Ribble Valley Borough Council
Housing & Development Control

Your ref: 3/2023/0178
Our ref: D3.2023.0178
Date: 14th April 2023

Application no: **3/2023/0178**

Address: **1 Moorland Road Langho BB6 8EX**

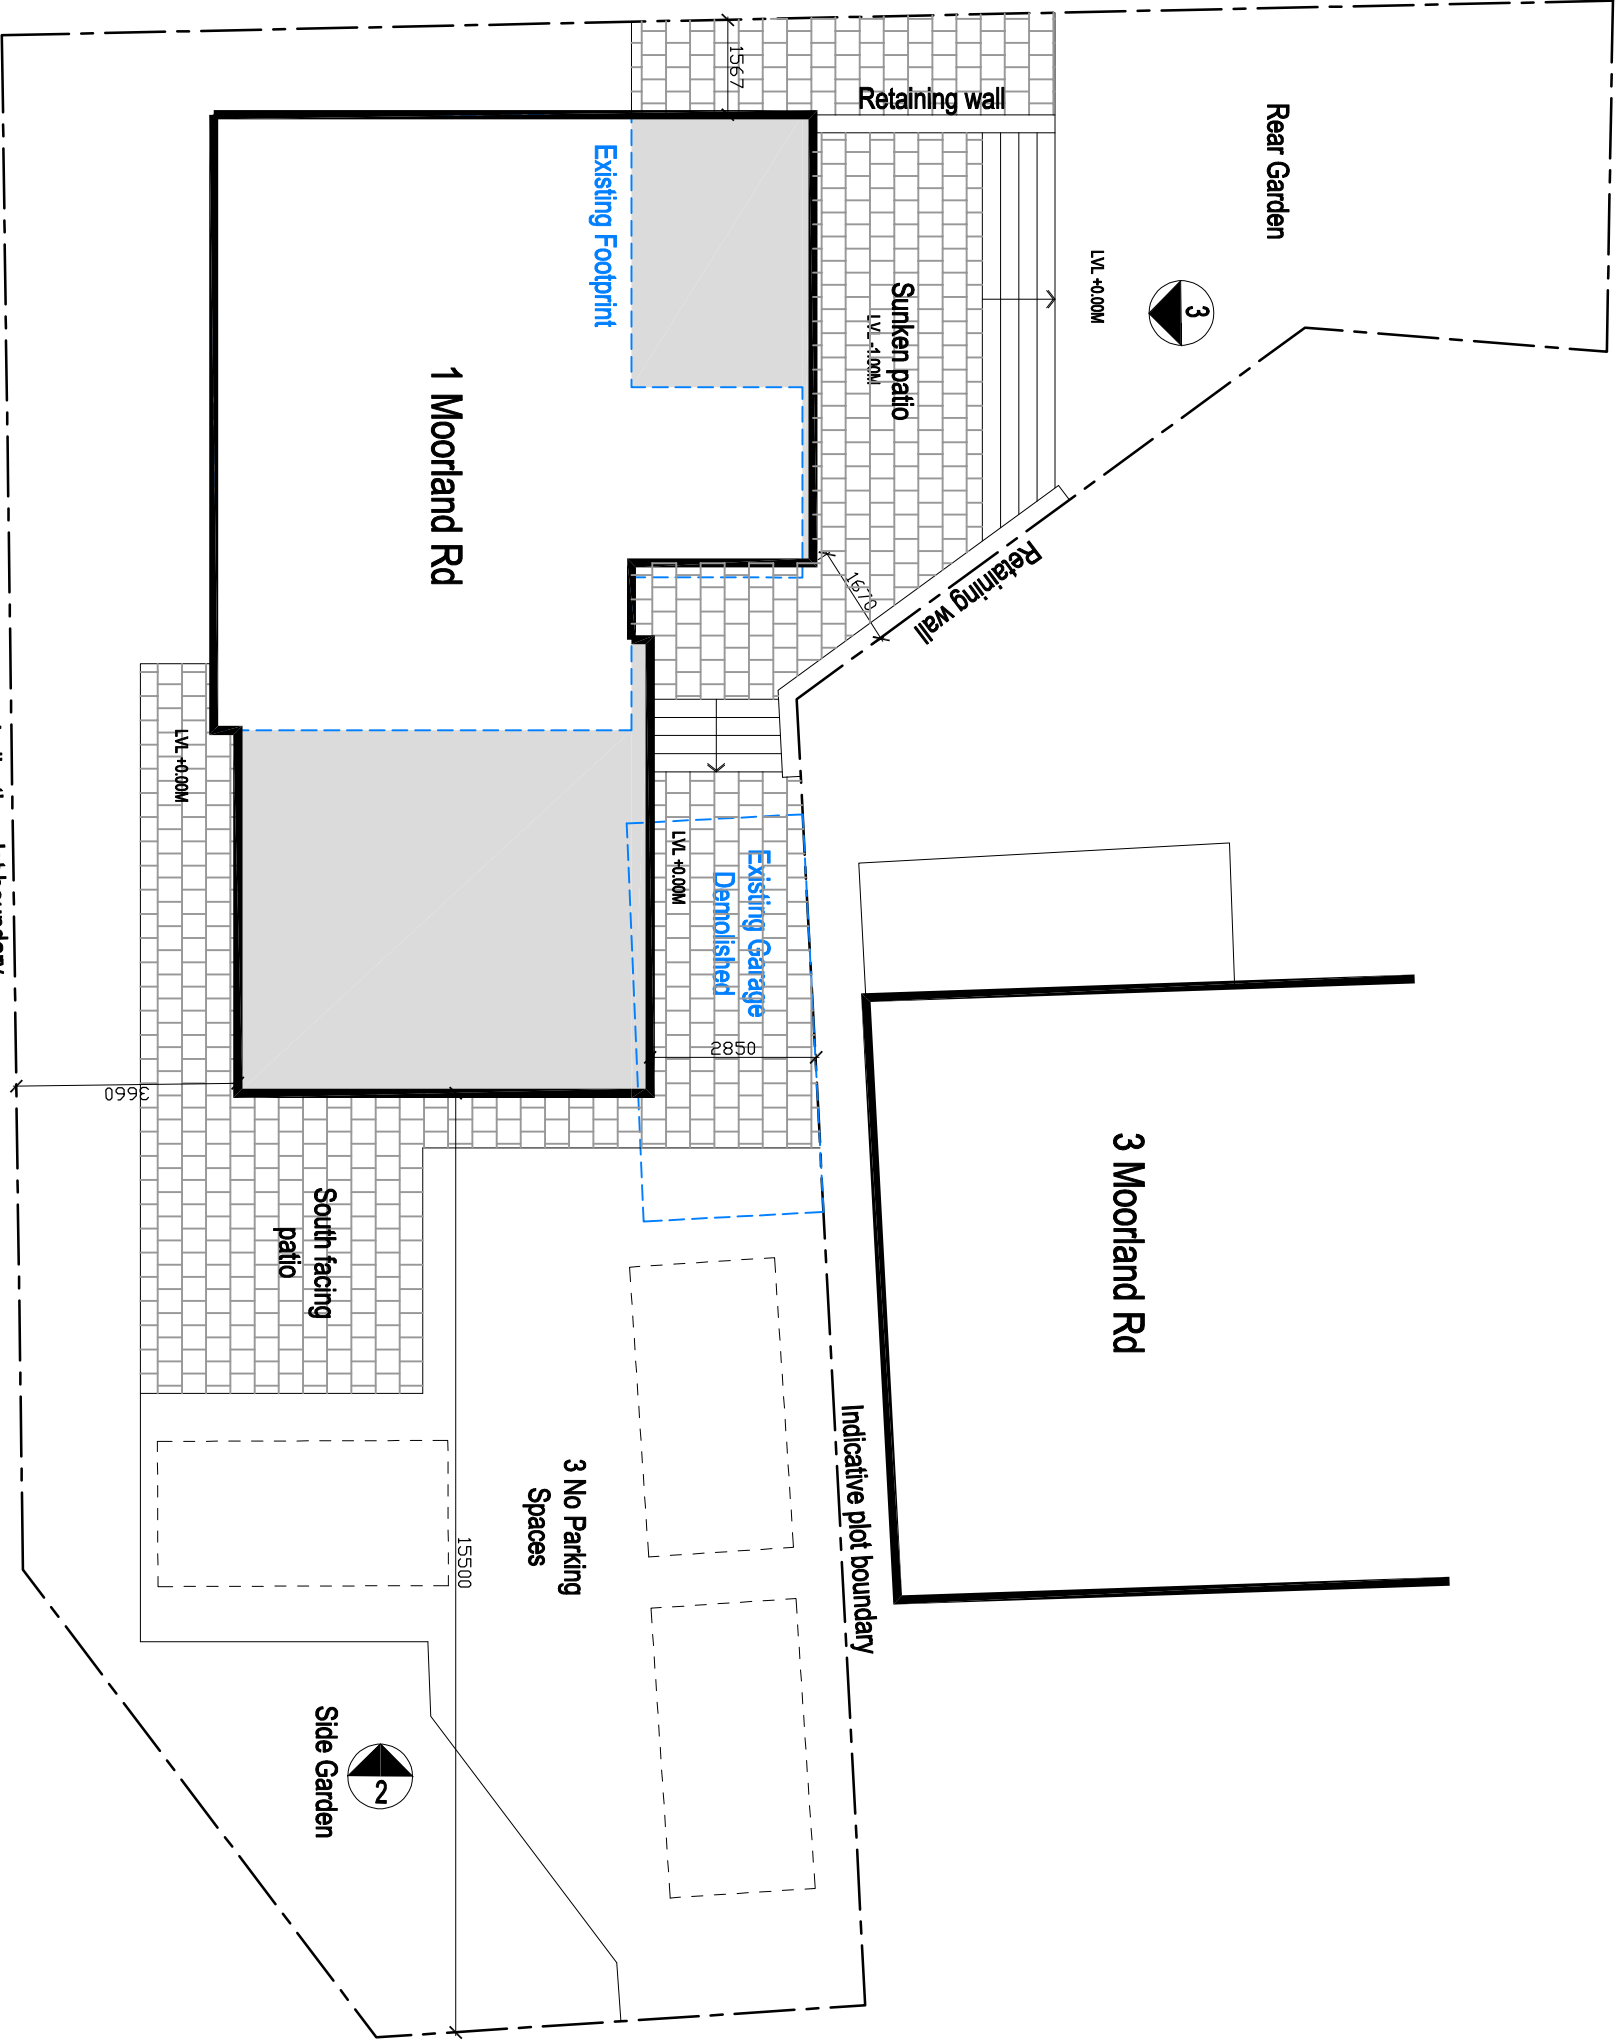
The LHA have reviewed AW+A drawing number PL/14 Rev A titled "Proposed Site Plan" and are aware that 3 car parking spaces can be provided for the proposed 4 bed dwelling which complies with the parking standards as defined in the Joint Lancashire Structure Plan. Therefore, the LHA have no objection to the proposal.

1. The development hereby permitted shall not be occupied until such time as the parking and turning facilities have been implemented in accordance with AW+A drawing number PL/14 Rev A. Thereafter the onsite parking provision shall be so maintained in perpetuity.
